WEST SUSSEX COUNTY COUNCIL CONSULTATION

TO:	Arun District Council FAO: Mrs Anita Gardner
FROM:	Highways, WSCC
DATE:	29/10/2018
LOCATION:	Asda, Littlehampton Road, Ferring, Worthing, BN12 6PN
SUBJECT:	FG/163/18A 4 No. non illuminated fascia signs, 2 No. non illuminated traffic signs & 1 No. internally illuminated totem sign at various locations (partial resubmission following FG/24/18/A).
DATE OF SITE VISIT:	n/a
RECOMMENDATION:	☒ Advice ☐ Objection ☐ Modification ☐ No Objection ☐ More Information ☐ Refusal
S106 CONTRIBUTION TOTAL:	n/a

Site Plan

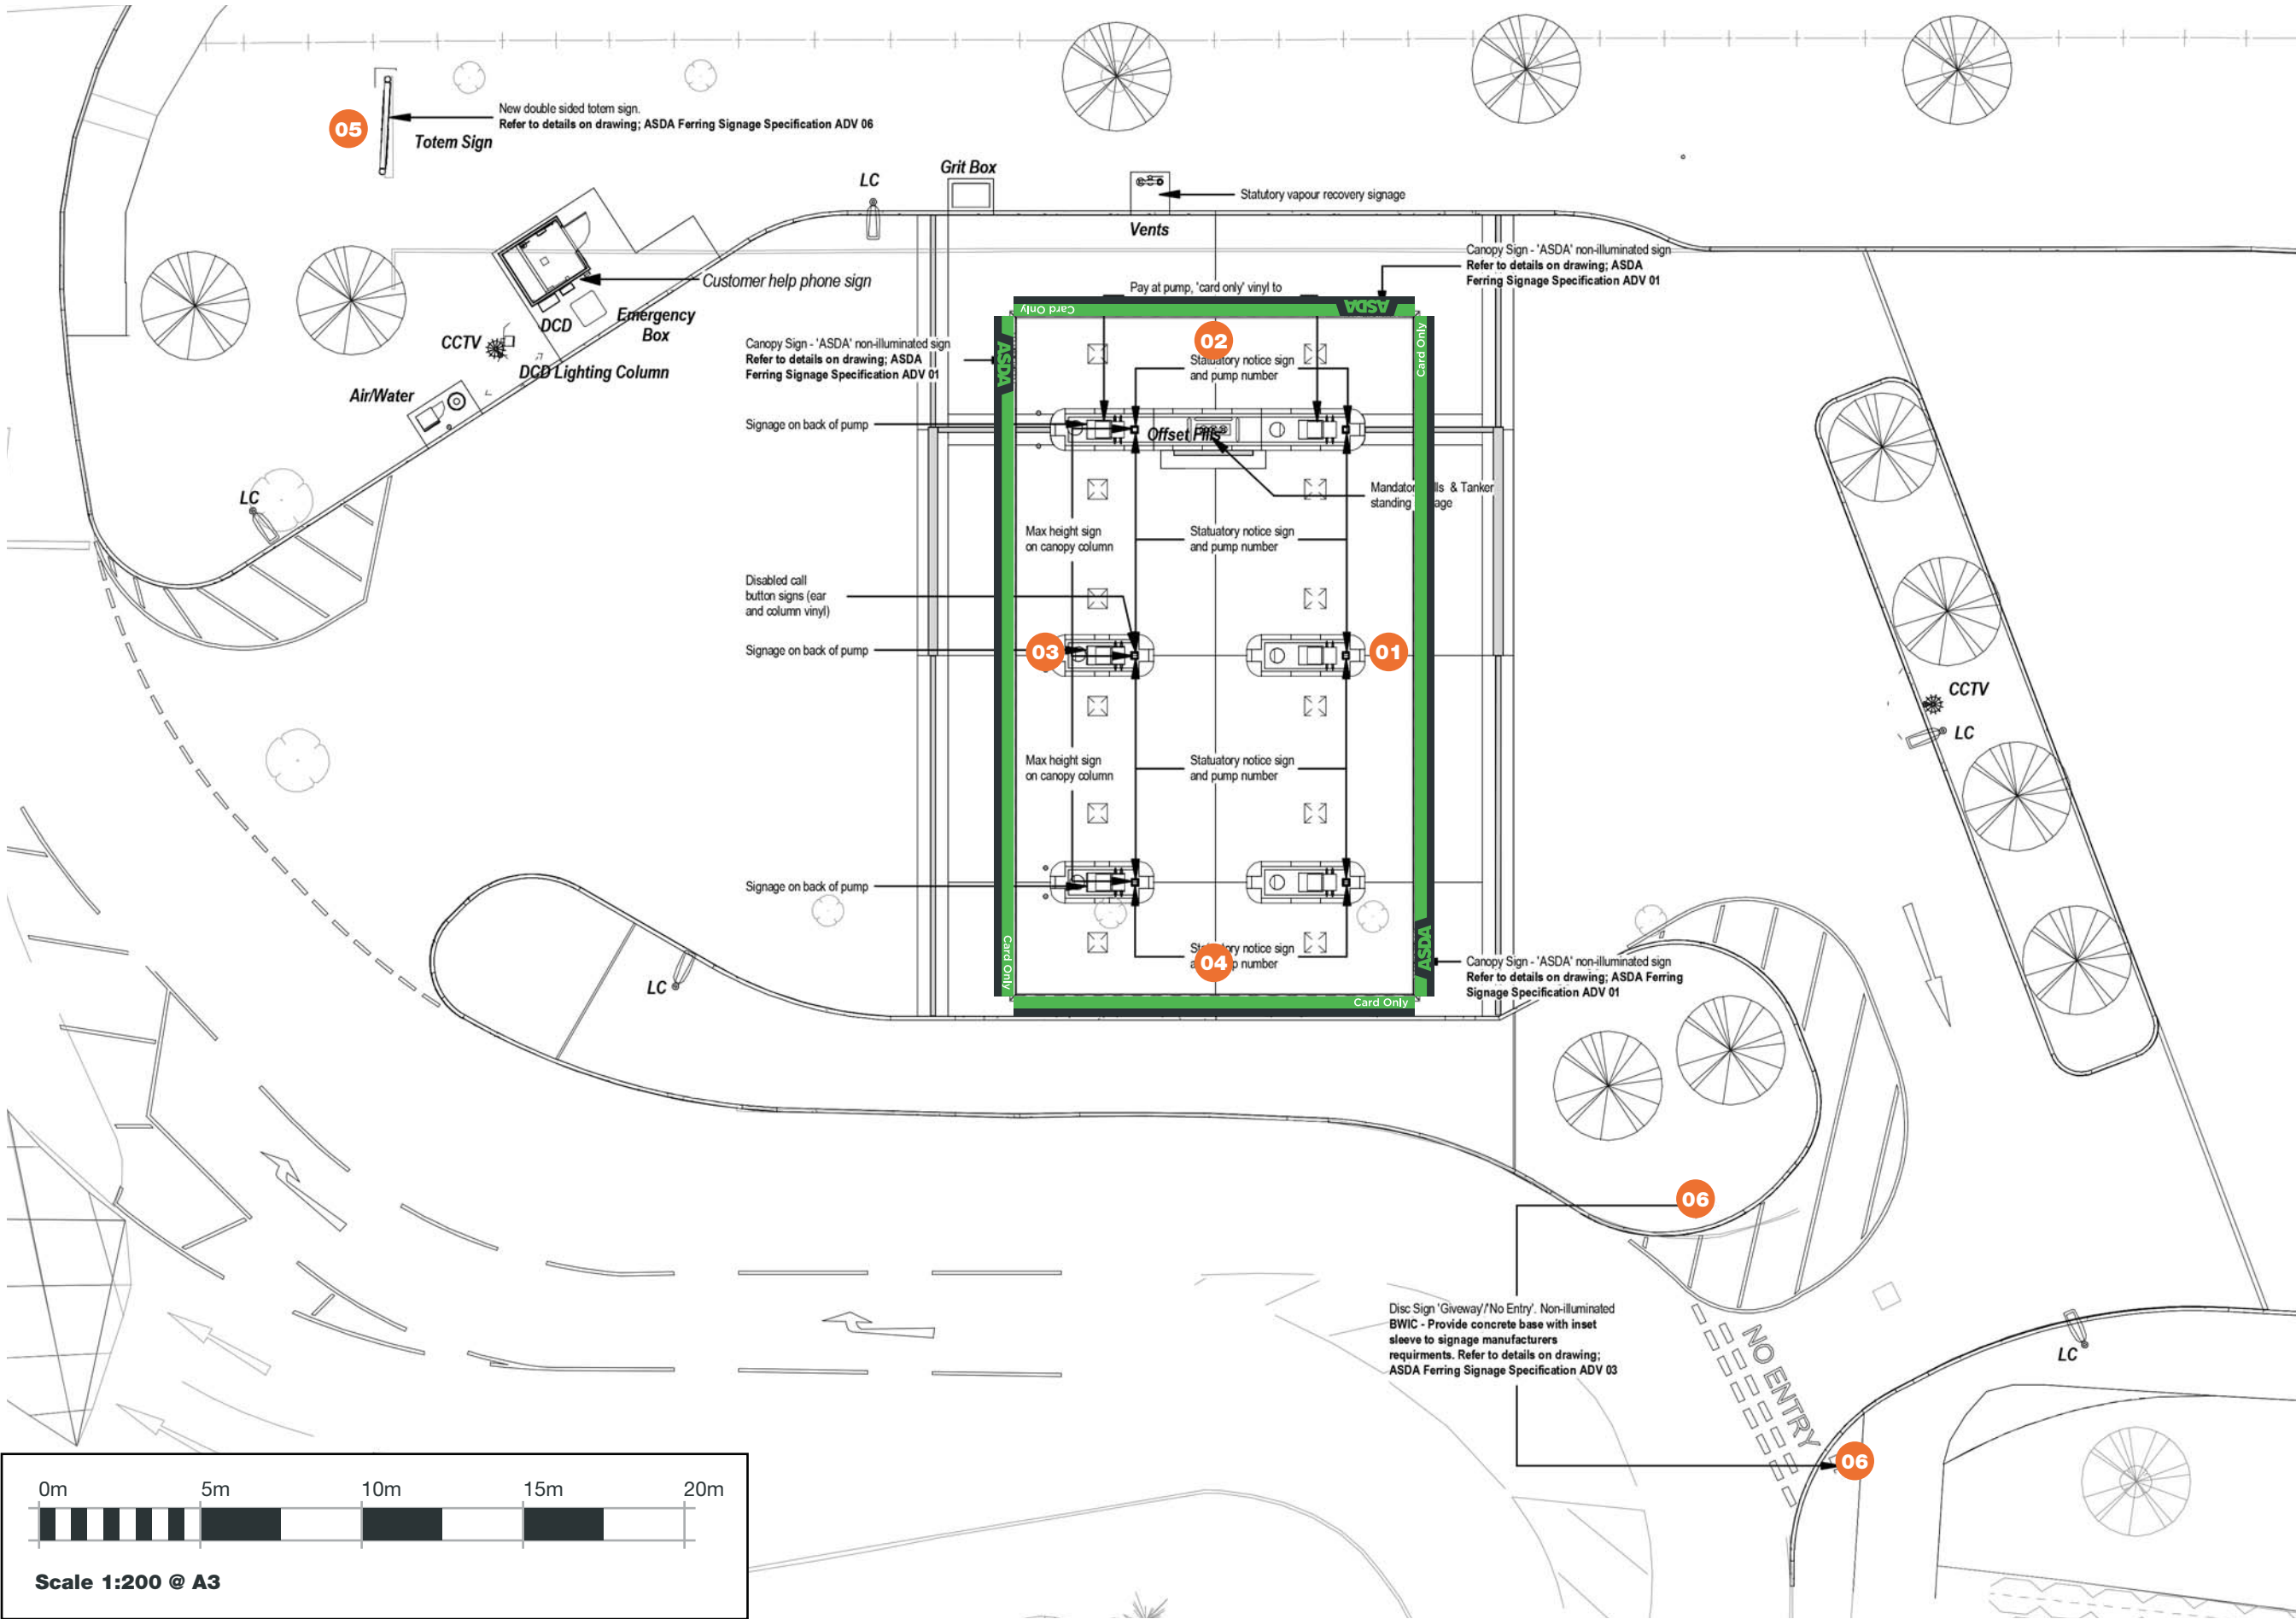
From inspection of WSCC mapping the proposed signs are not to be positioned on land considered to be public highway.

The signs are not in positions which would obstruct vehicular visibility at the access with Littlehampton Road, A259.

Totem Sign - ADV 06 Scale 1:50

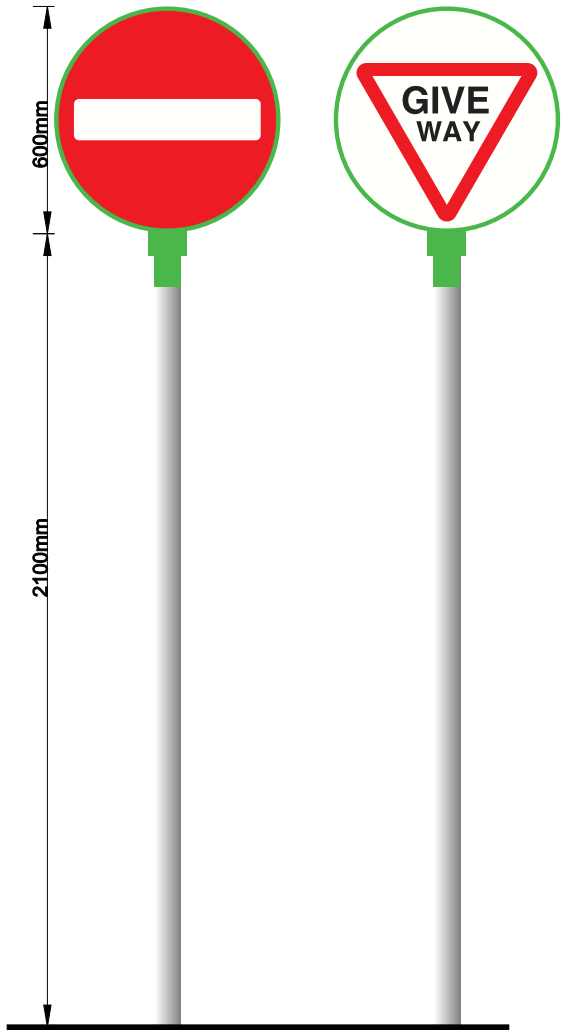
The luminance levels of the proposed illuminated signs are below the maximum luminance recommended by The Institute of Lighting Engineers for an area such as this.
